Condition 11- Surface Water Drainage Design

Application No: CM/11/21/DOC

Site Address: Scyld Horsemere Green Lane Climping BN17 5QZ

Description of Works: Approval of details reserved by condition imposed under CM/21/19/PL relating to conditions 11-surface water drainage scheme, 12-discharge of flows to water courses or for the culverting, diversion, infilling or obstruction of any water course on or adjacent to site & 13-maintenance and management of surface water drainage system.

HEADWALL STRUCTURE FOR OUTLET PIPE

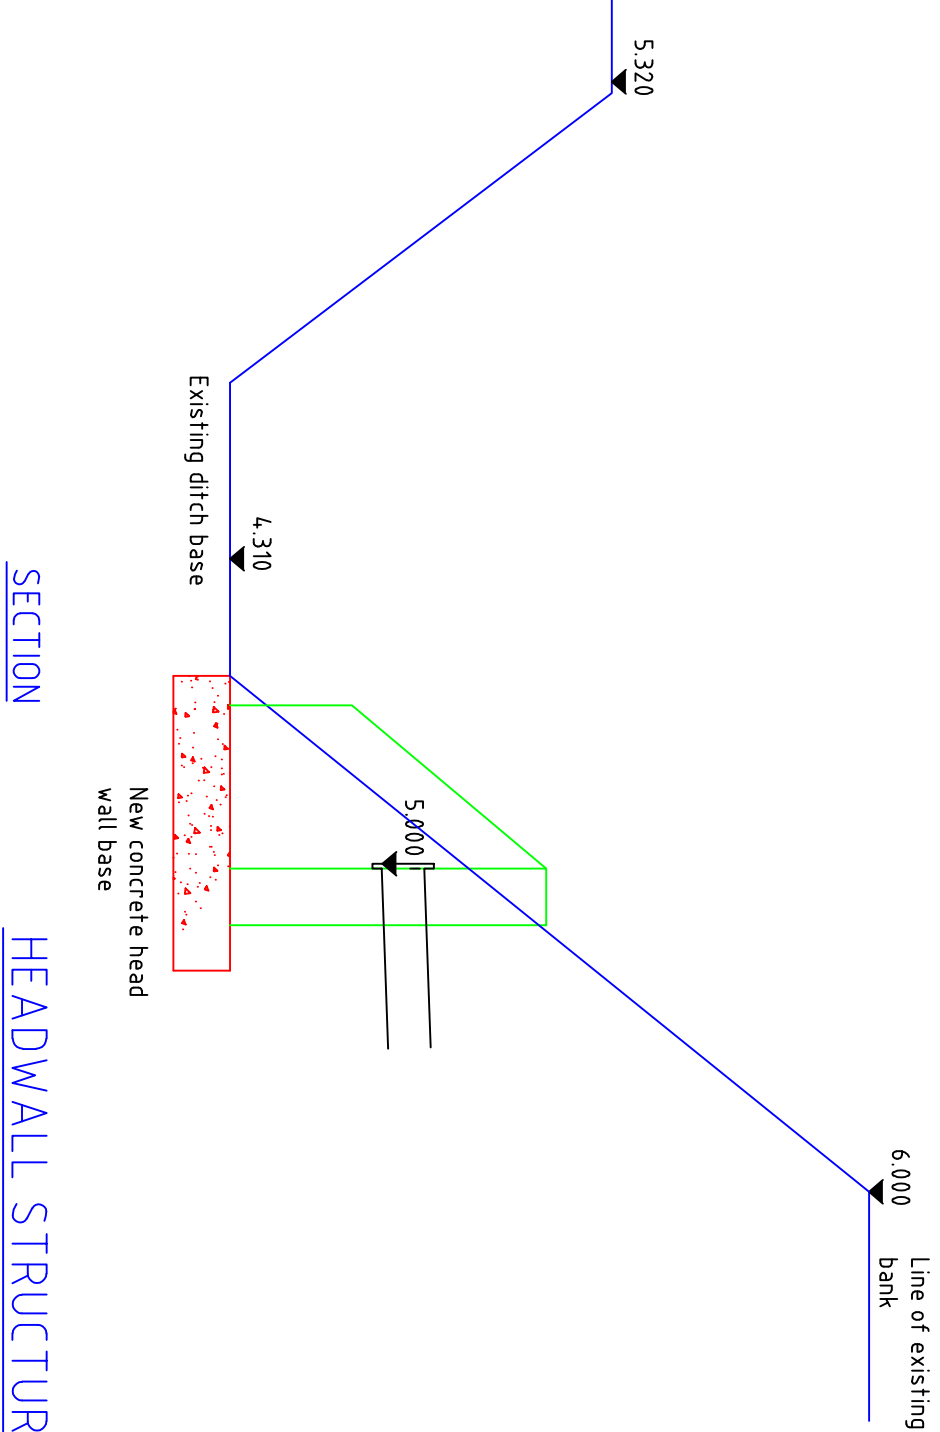
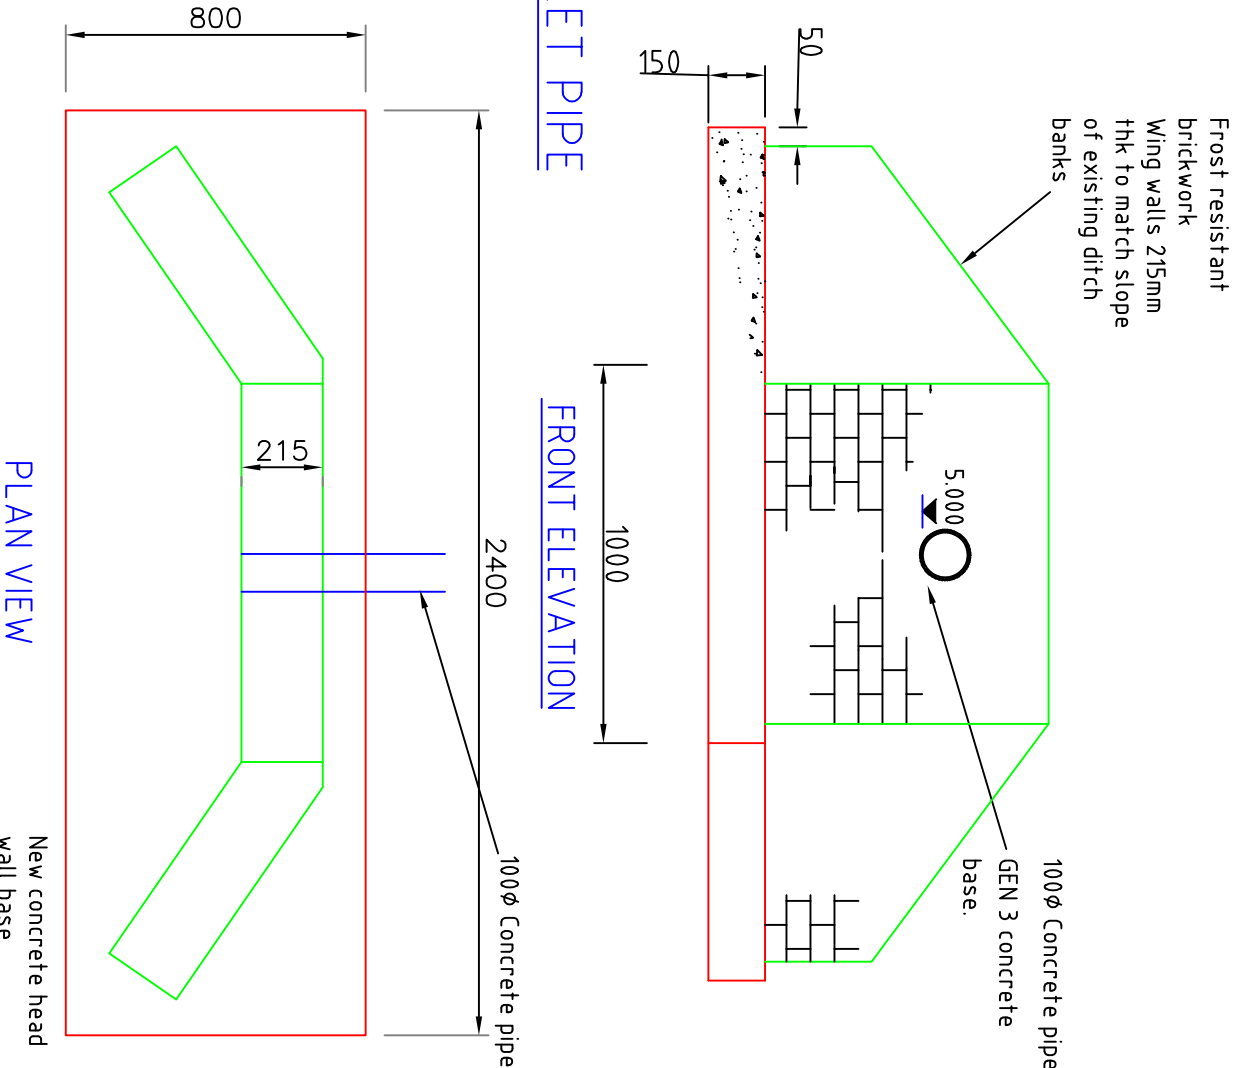
6. Please detail all pipe diameters and falls on plan.
7. No connections are shown to/ from the permeable car park areas.
8. Please provide site specific construction detail drawings of the proposed headwall, this should include a plan and full cross section through the ditch. All headwall drawings should indicate existing bed level, and top of bank level.

Proposed Impermeable Areas - Scale 1:500

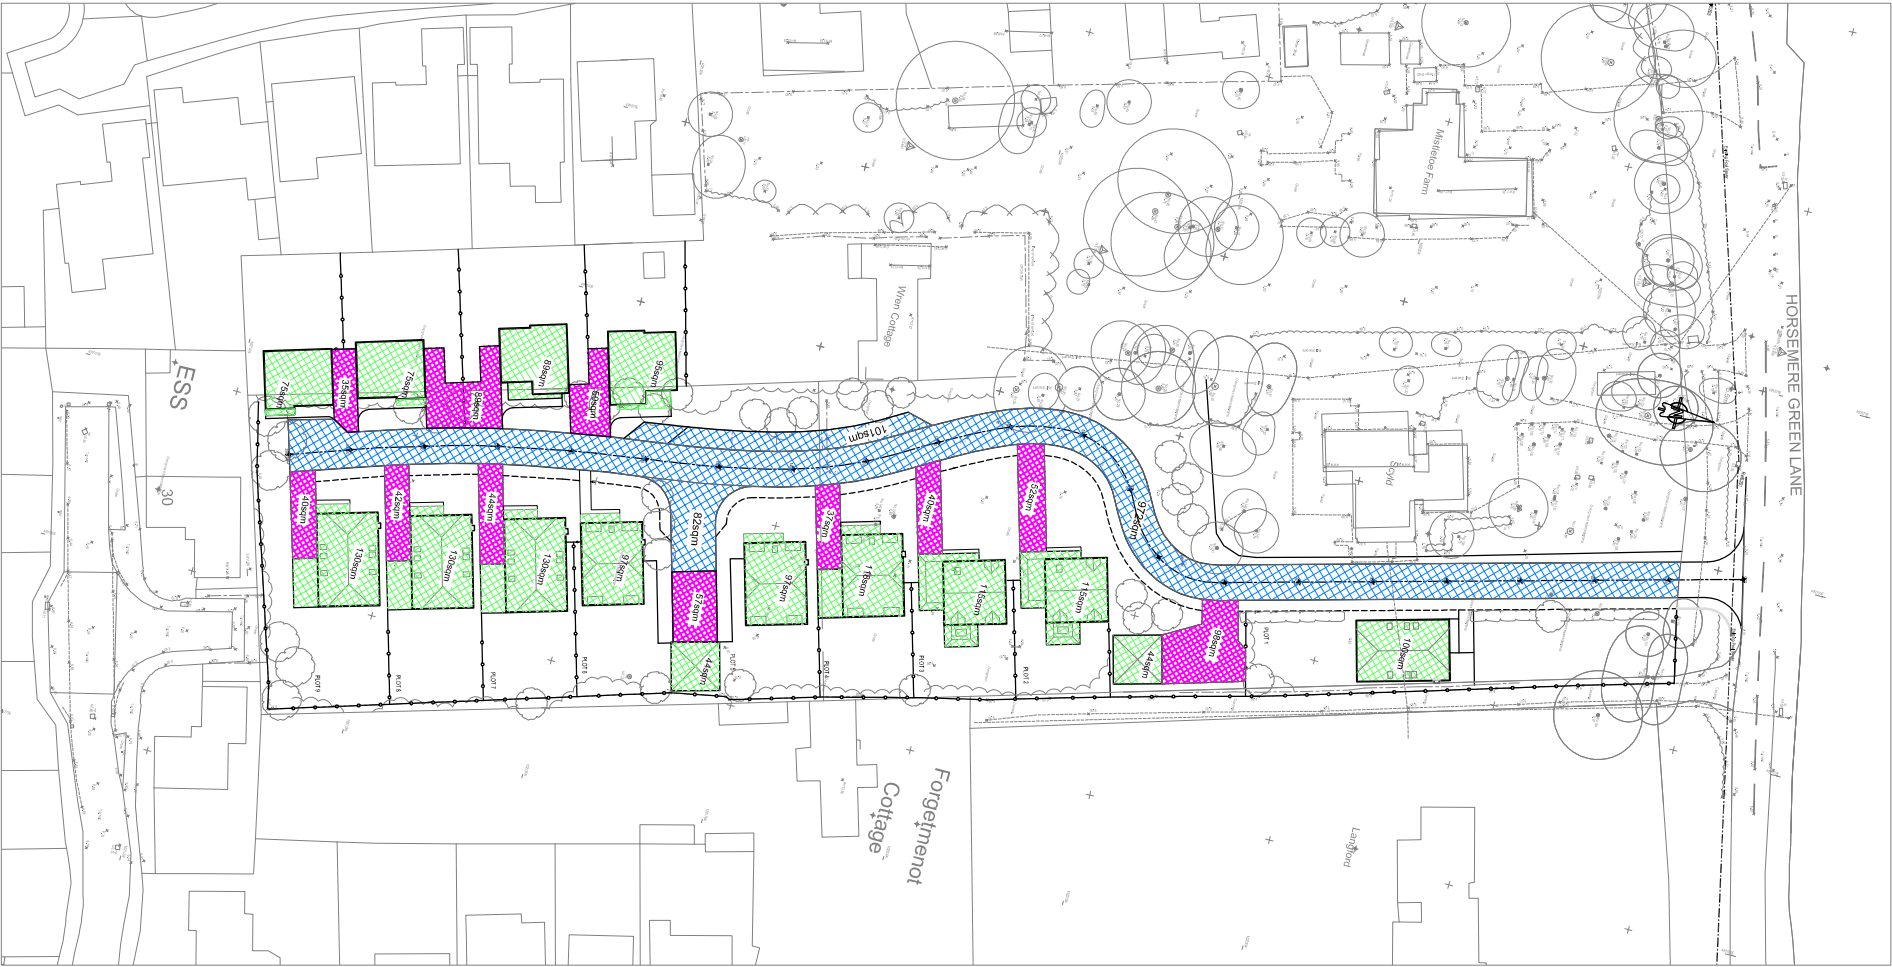
2. The impermeable areas plan appears to use an old layout, not the latest layout as approved under CM/55/20/PL. Please provide an updated impermeable areas plan.
